Submission No.			043		
Organisation Name or Name of Submitter			Ciaran Black and Leon McCarthy		
Item No.	Section Ref.	Page No.	Observation Statement	TII Response	
Railway (Metrolink-Estuary to Charlemont via Dublin Airport) Order 2022 Case Reference Number NA29N.314724 - Residents of 33 Dartmouth Road - Submission to Metrolink Railway Order application					
1	Letter - opening statement	1	While we in favour of the broad aim of the Metrolink project to connect Dublin's city centre to our national airport, as a resident living in the Dartmouth/Charlemont area, we wish to set out a number of observations, for the Board's consideration, regarding the proposal to locate the Terminus station at Charlemont- Dartmouth. Our family home is in the midst of the community where the Terminus station at Charlemont is proposed to be located, and is dangerously close to the proposed very deep pile insertions and deep station box excavations. The impacts of the Metrolink proposal on our family home during both construction and operational phases is profound and will result in a fundamental loss of amenity, loss of property value and represents a profound 'interference with the right to the peaceful

Drawing Title  
**Figure 14.2 Groundborne Noise from Tunnel Boring Machine**  
Sheet 1 of 7

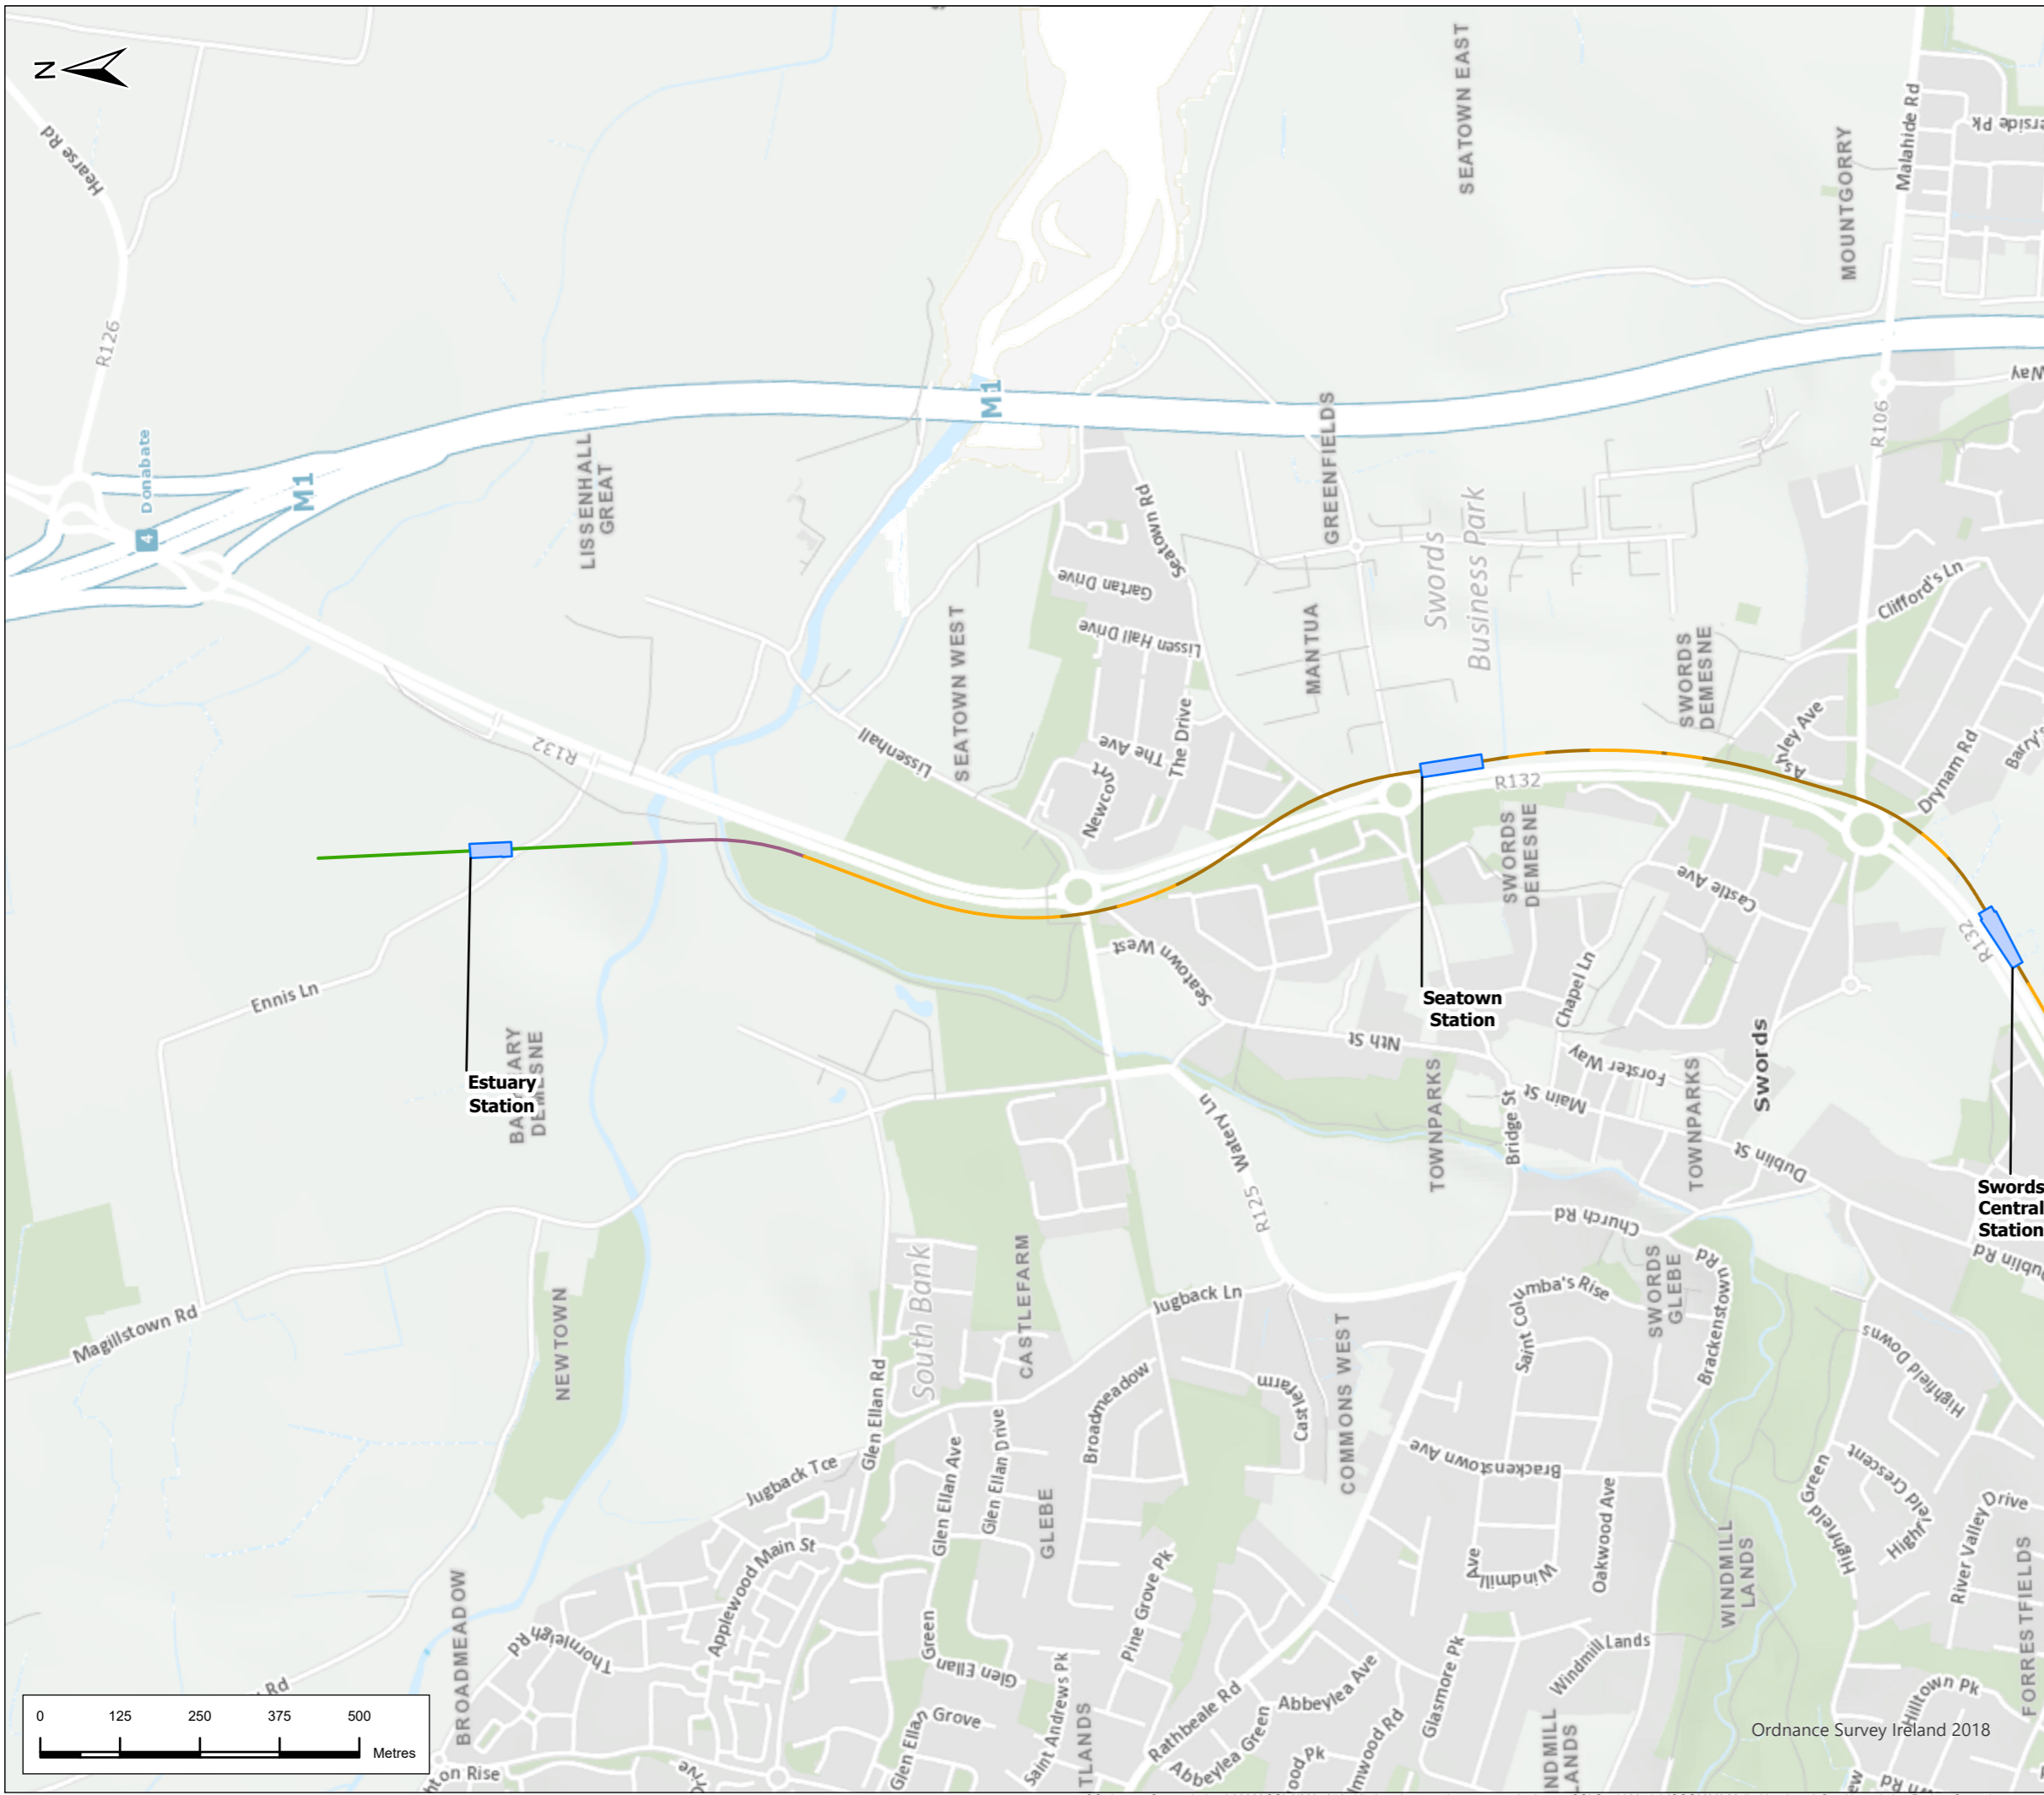
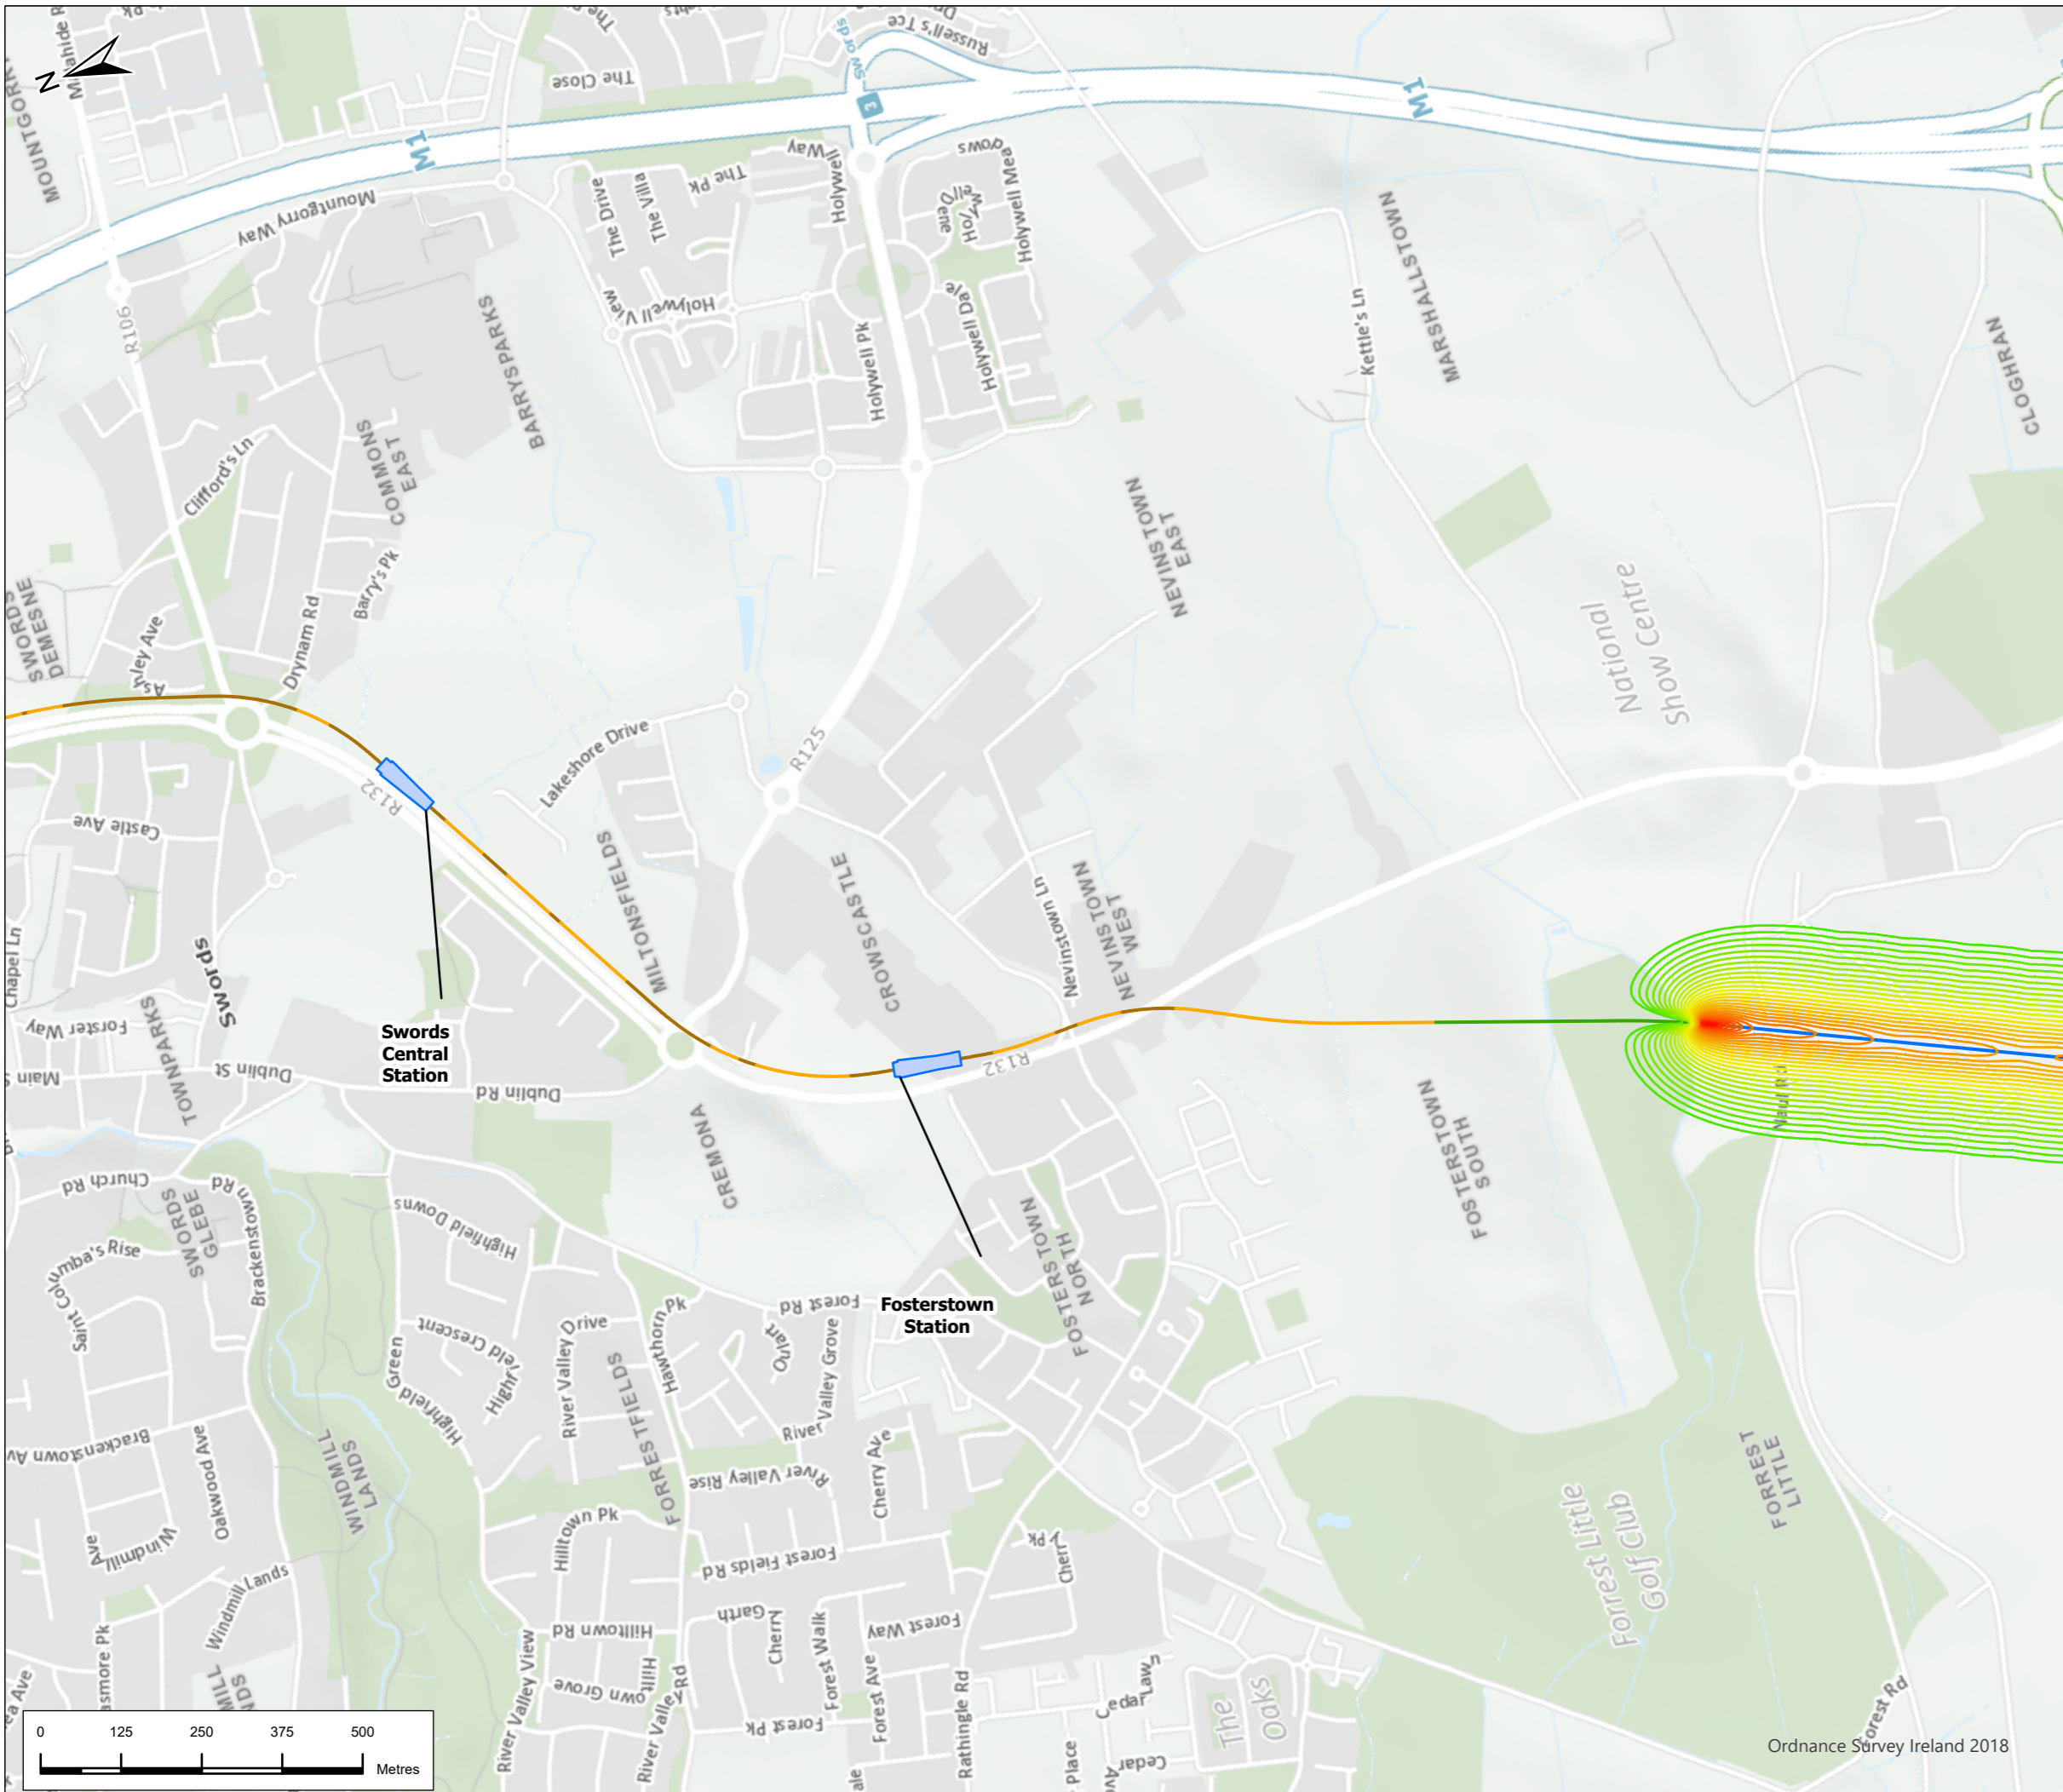
30	Inadequate EIAR	11	<ul style="list-style-type: none">• The ground borne vibration/noise impacts of the train operations upon the houses of Dartmouth Road have not been assessed.	<p>This statement is incorrect. EIAR Appendix A14.5, Groundborne Noise and Vibration and Blasting Modelling Results, Section 14.4 AZ4 Northwood to Charlemont, presents the predicted vibration levels during railway operation for sensitive receptors. The predicted groundborne noise at 33 Dartmouth Road is 28 dB LASmax, which is below the threshold level of 40 dB LASmax, indicating no significant impact during railway operation. The predicted VDV (Vibration Dose Value is a parameter that combines the magnitude of vibration and the time for which it occurs) during railway operation is 0.005 ms-1.75 (VDV day) and 0.003ms-1.75 (VDV night). Both of these values are well below the VDV Threshold Levels of 0.8ms-1.75 (VDV day) and 0.4ms-1.75 (VDV night) indicating no significant impact for the building or for residents of this address.</p>

Figure 5-8: Impact of Works on Dartmouth Road

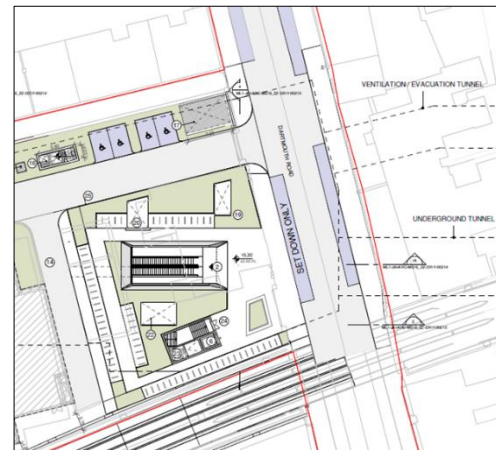
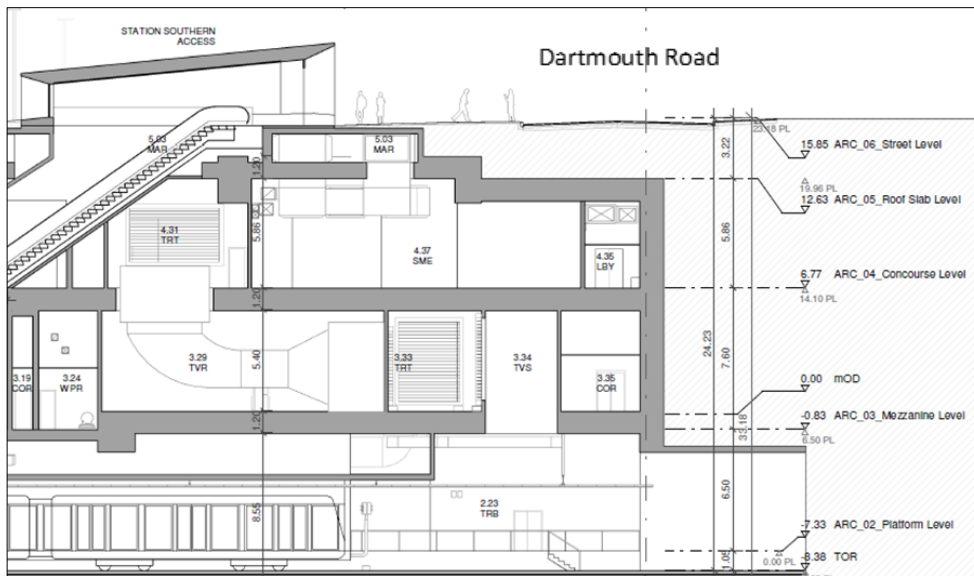
23	3.2. Main Issues raised in the CDCG Dartmouth Road Submission 2 Policy and Procedure	11	<p>The documentation and in particular the drawings submitted are misleading and do not illustrate the relationship between the proposed station works and the houses on the southern side of Dartmouth Road. The deep construction required immediately adjacent to residential houses is wholly inappropriate and will result in a very severe loss of amenity and devaluation of property.</p>	<p>TII disagree that the documentation and drawings submitted are misleading and do not illustrate the relationship between the proposed station works and the houses on the southern side of Dartmouth Road. Drawing ML1-JAI-SRD-ROUT_XX-DR-Z-02090 (Structures Details Book 2 of 3) shows the outline of the underground station, property Drawing ML-P 307 0-A (Property Details, Book 2 of 2) also shows the footprint of the station in relation to surrounding property, as does Alignment drawing ML1-JAI-ARD-ROUT_XX-DR-Y-03096 (Alignment Details Book 2 of 2). Regards drawing ML1-JAI-SRD-ROUT_XX-DR-Y-02096, the relationship of the section shown to Dartmouth Road is a function of where the long section has been taken and is therefore correct.</p> <p>Neither do TII agree that deep construction adjacent to the residential houses is inappropriate and would also note the environmental impacts have been carefully considered. TII would also note that while TII are of the view that the construction environmental impacts can be mitigated, relocation is an available option for Dartmouth Road residents immediately adjacent to the construction site during peak construction. TII are available to discuss this option if that is something the property owner would like to explore and consider.</p> <p>Regards loss of amenity during construction, Dartmouth Road will be closed between Dartmouth Place and Dartmouth Square West during the enabling works and main works but diversions will be put in place for local access, including deliveries, emergency services, bin collection, and pedestrian access maintained to property. The impacts on parking will be monitored during construction to reinstate any disrupted areas as soon as practicable. On completion of construction, parking will be reinstated.</p> <p>TII are of the view that the proposed development will have a long term positive affect in terms of property value. There is evidence to suggest that property values will in fact increase in close proximity to public transport infrastructure and that local residents will greatly benefit from having a world class metro system providing access to the city centre, airport and north city at their door step.</p>
